DEVELOPMENT REVIEW BOARD
TRANSPORTATION DEVELOPMENT

DRB Project Number: 2021-001579
Winrock Park

SUBJECT: Plat, Site Plan

ENGINEERING COMMENTS:

PROJECT TITLE: WINROCK TOWN CENTER
 2100 LOUISIANA BLVD.
 PROJECT NUMBER: JOB NO.
 DRAWN BY:
 SHEET TITLE: DRB ROAD E GRADING PLAN

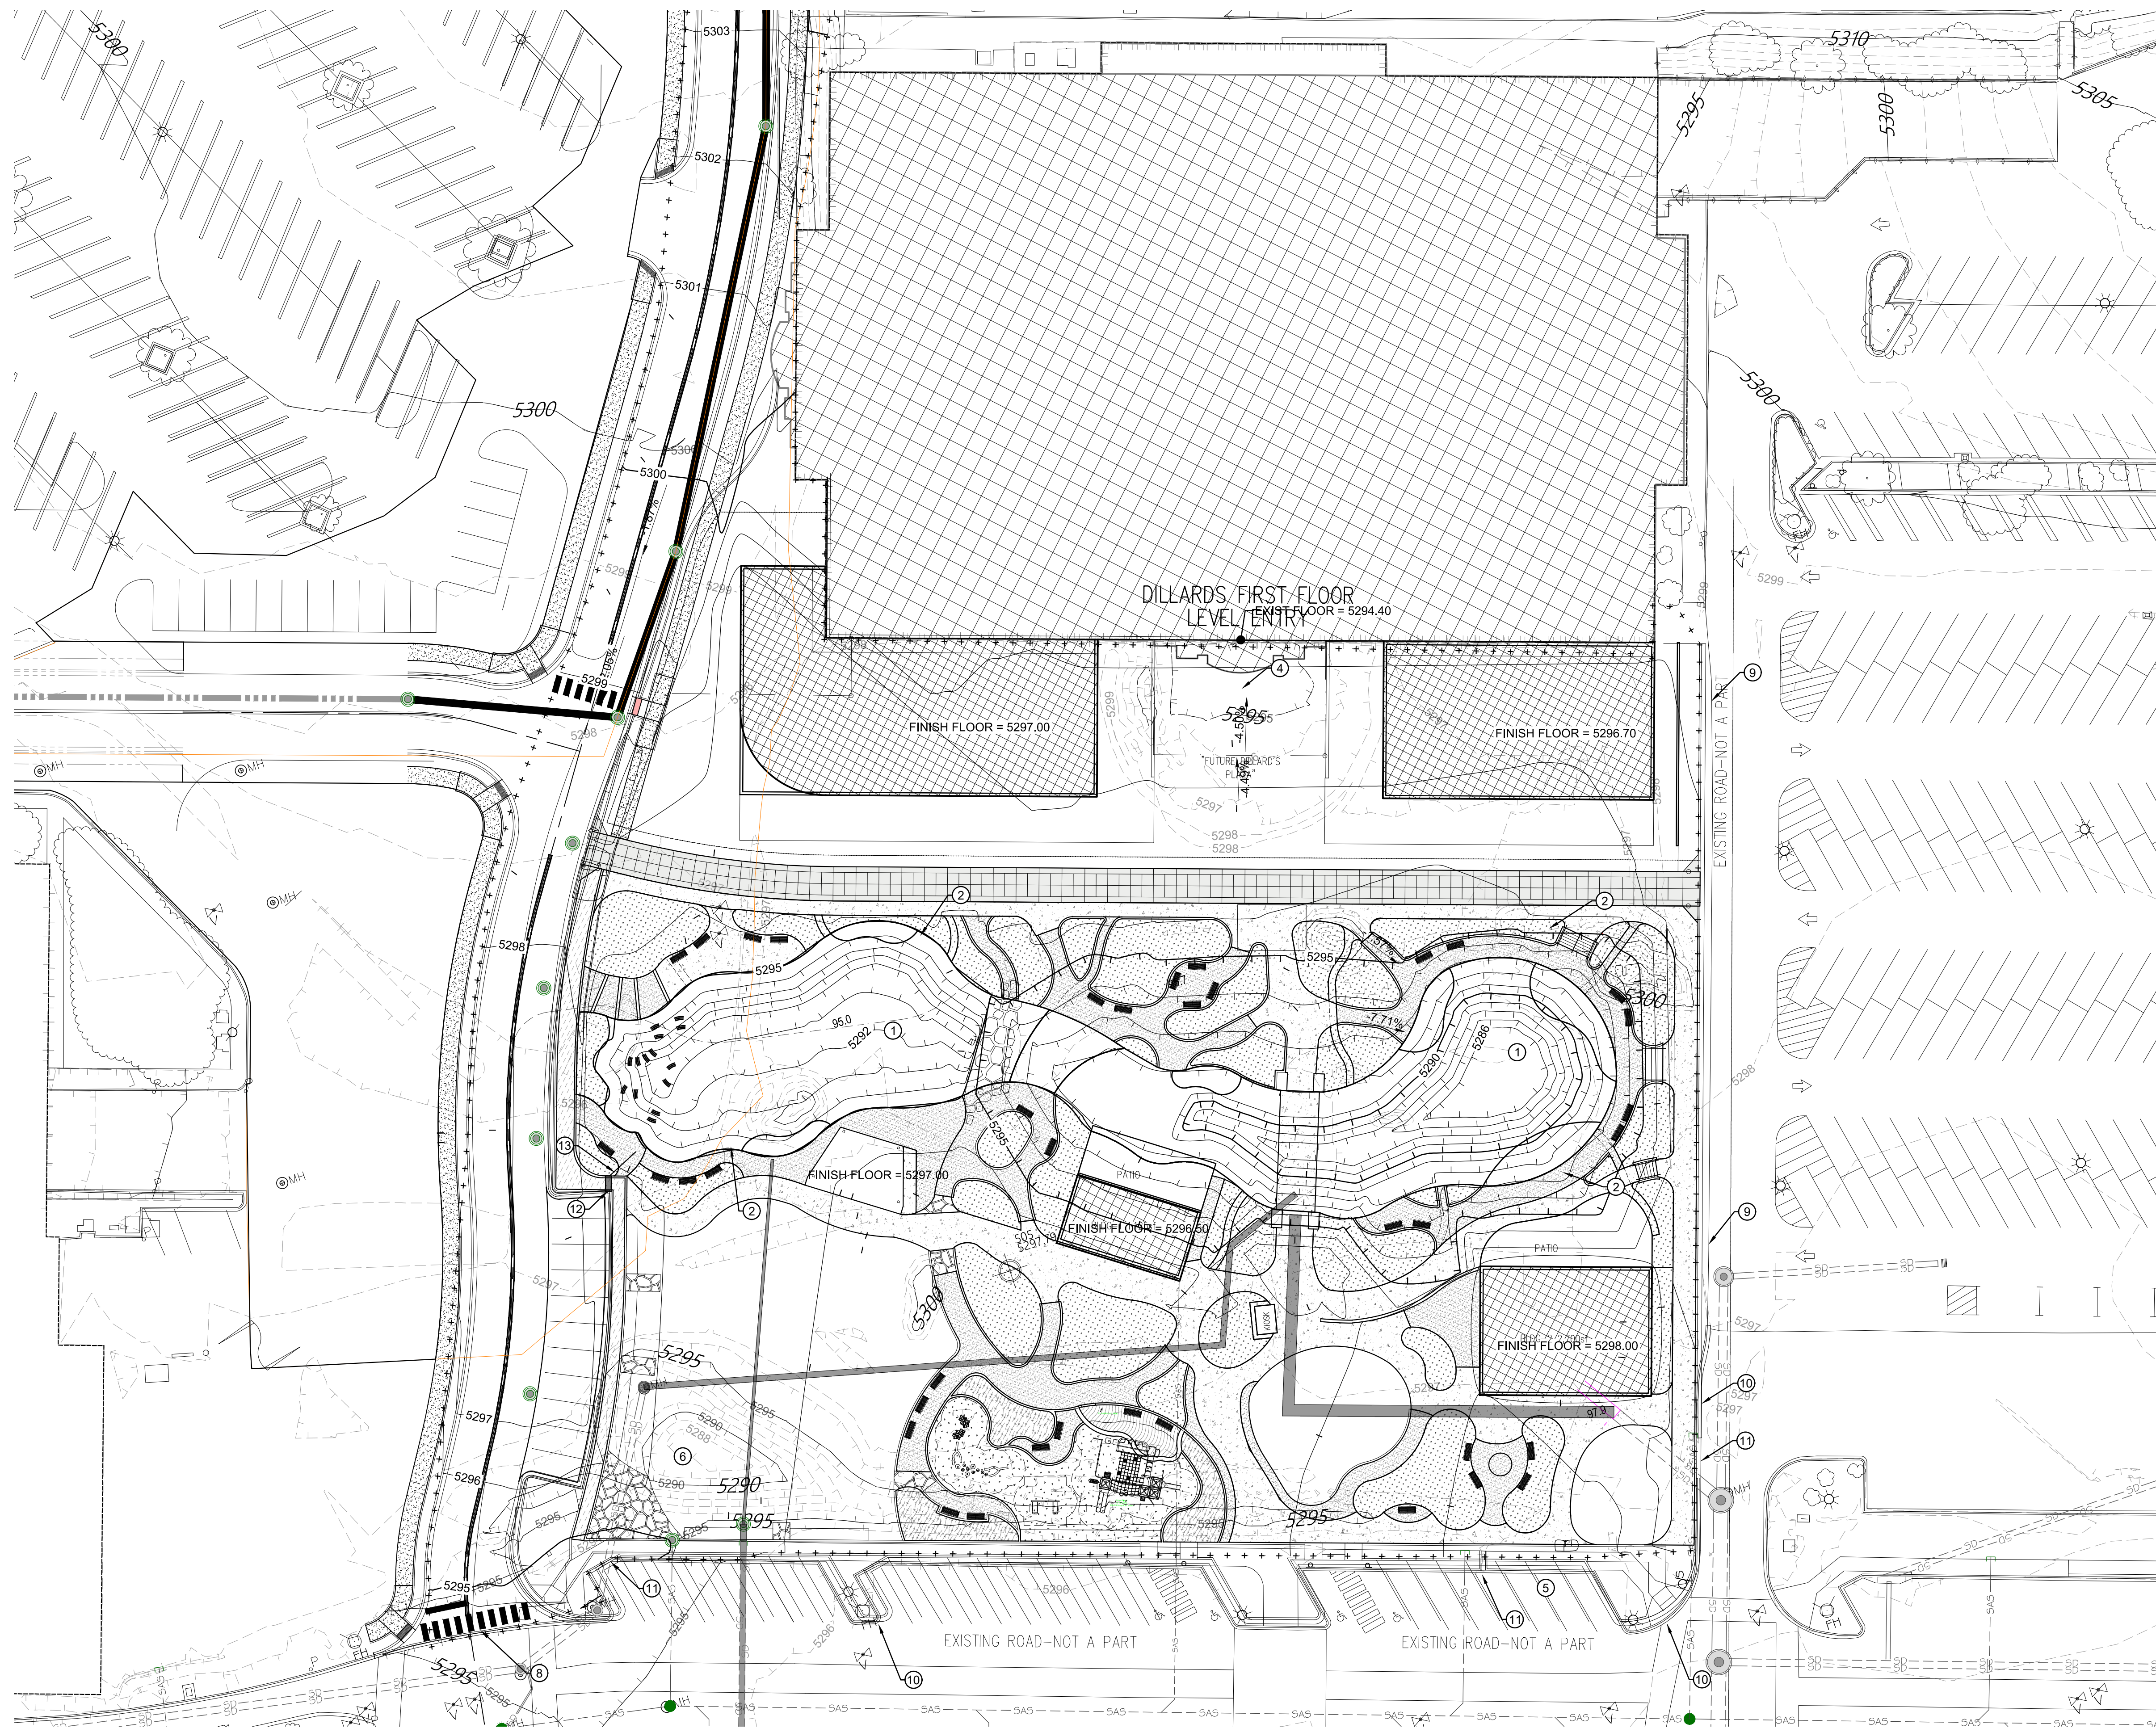
1. Stamp and sign drawings.
2. Show cross-sections of Roadway E with cross-slopes, lane widths and sidewalks. Call out details for curb.
3. Label all handicapped signage and motorcycle parking signage on the plan.
4. Provide proposed traffic control at each of the new intersections. Add “Yield to Pedestrians” signage for the new crosswalks that are mid-block.
5. Include civil details with all signage, curb, ramps, and sidewalk, and crosswalk details. For the curb ramp and sidewalk details, indicate a 2% maximum slope for the sidewalk.
6. Label all new curb ramps on the site plan and reference curb ramp details. (It appears that in some cases, the wrong keyed notes were used for the curb ramps.)
7. “No Parking” shall be called out on all new van accessible aisles. However, this can be handled under the details.
